From: Rhiannon Lloyd
Sent: 15 June 2026 09:34
To: Planning.Responses
Subject: Fw: K/6/26/CLP - The Salterns
Attachments: 21012_GA00 (PLANNING).pdf

DRAWING TITLE	PROJECT NO.	DRAWING NO.
PROPOSED PLANS LEVEL 00 & 01	21012	GA.00
STATUS	DATE	REVISION
INFORMATION	02.2026

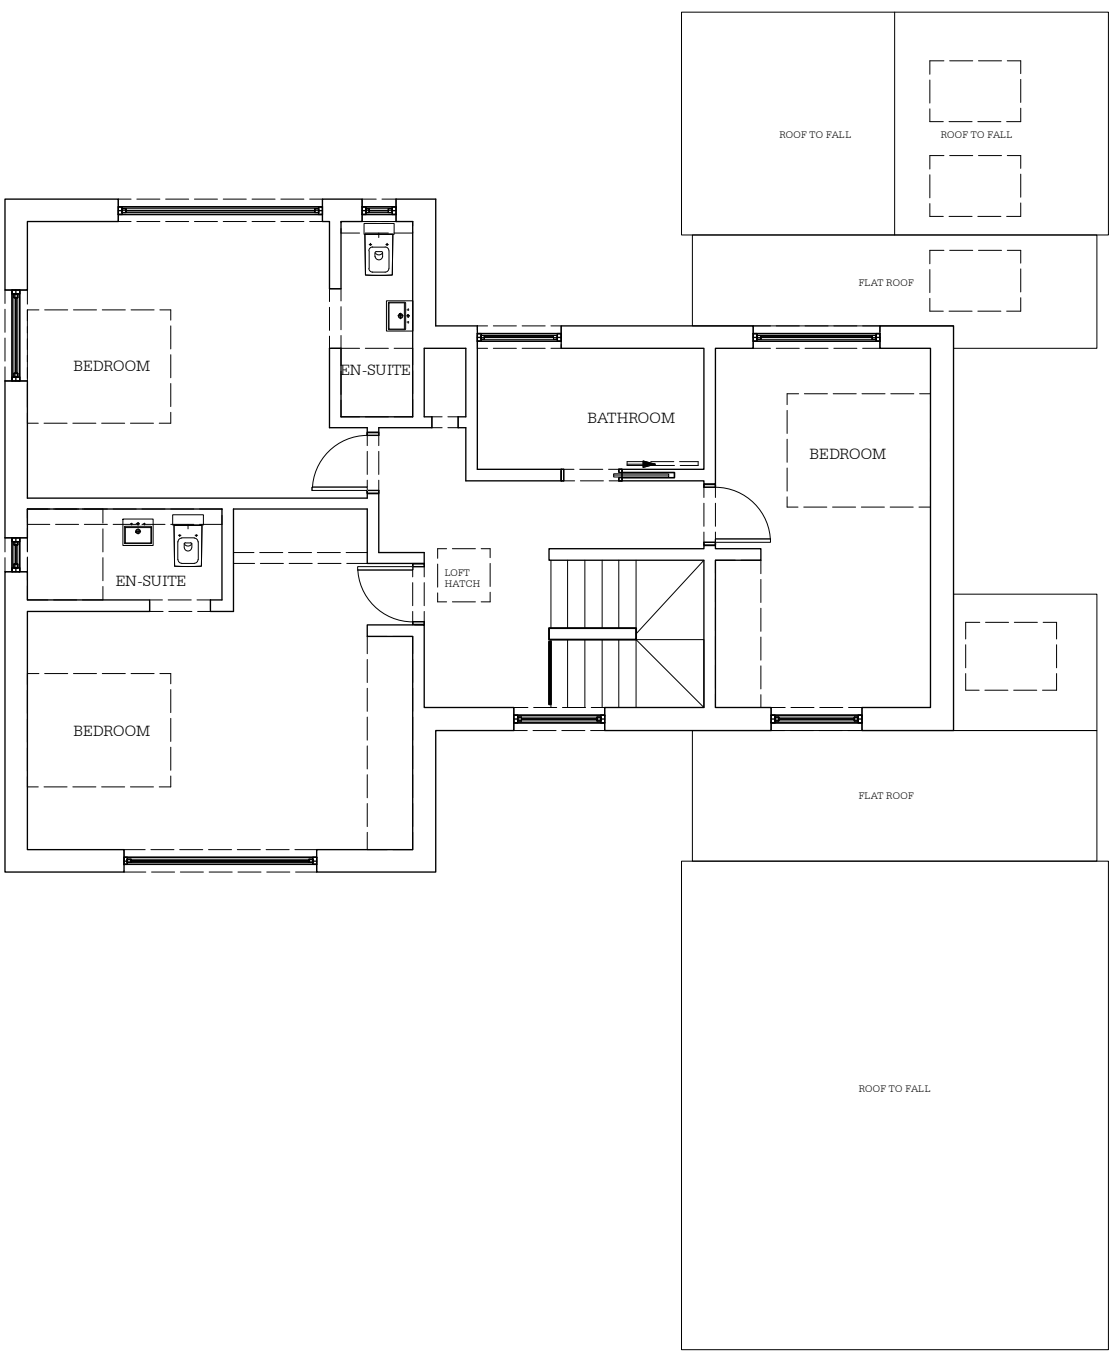
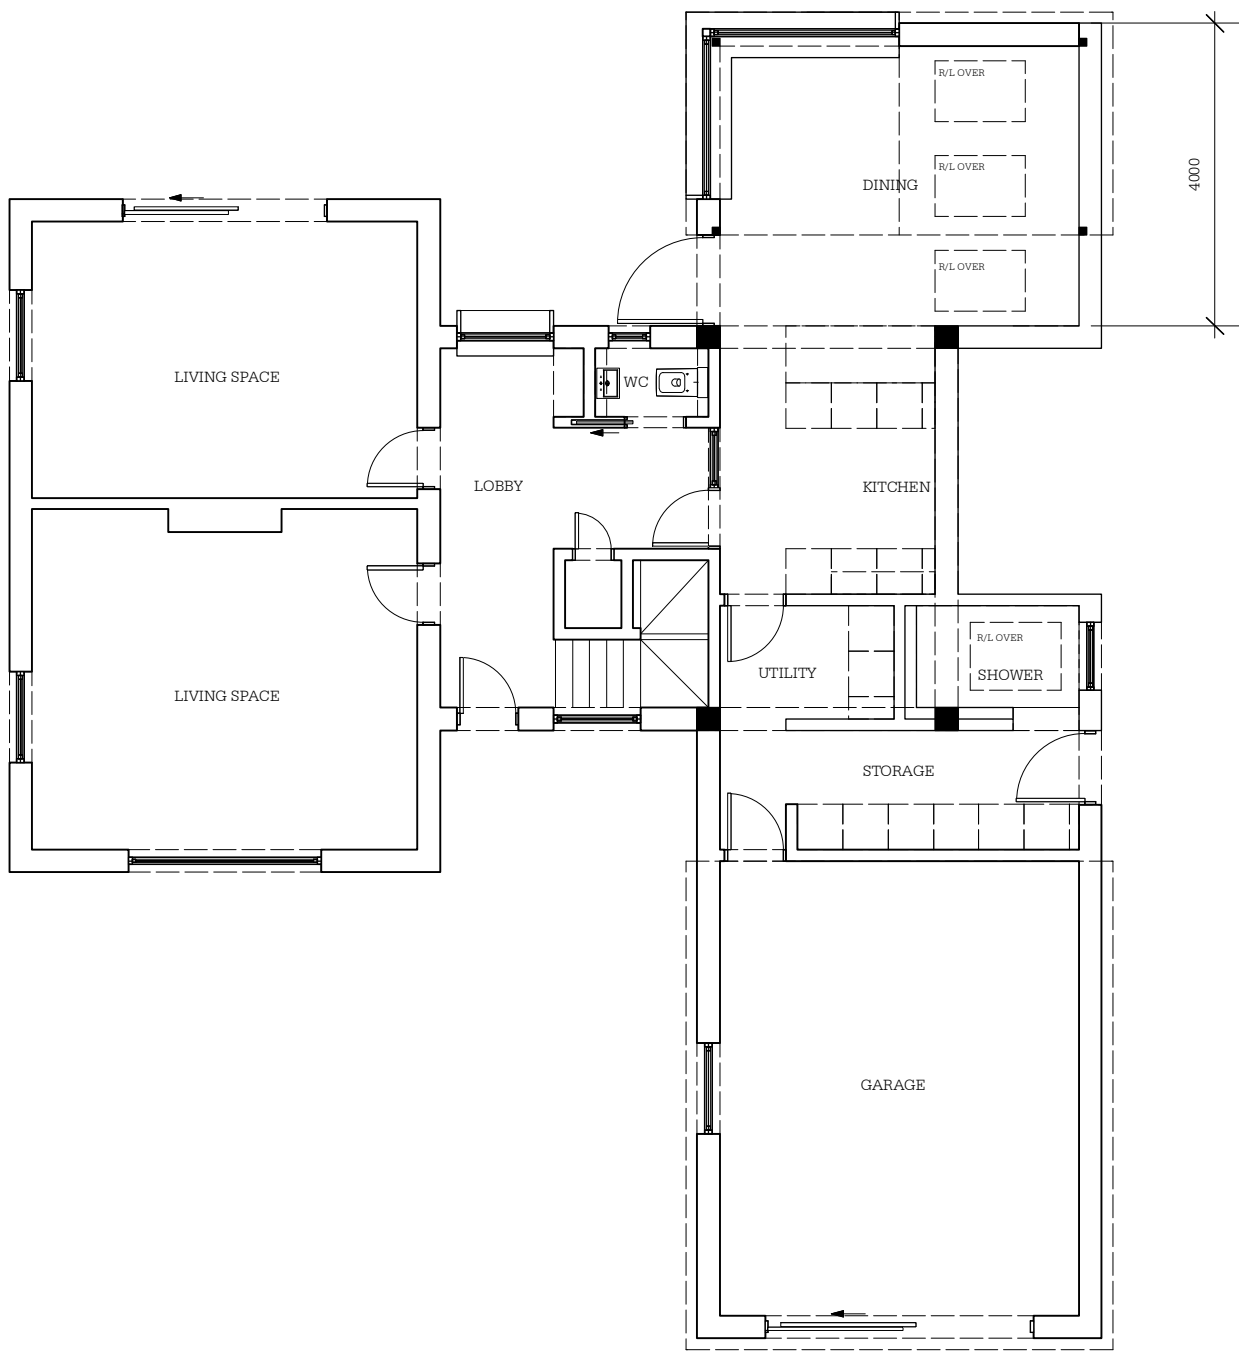
Thankyou for the below - the ideal is to infill this small gap - I'm assuming this does not compromise the PD compliance?

I since note that the block plan and floor plans to do match. The block plan shows a gap, while the proposed floor plans infill this area as part of the kitchen.

Please confirm and provide an amended plan of whichever is therefore currently incorrect.

Not a problem at all, we'll omit the infill for the purposes of this application and I'll send you the adjusted drawing.
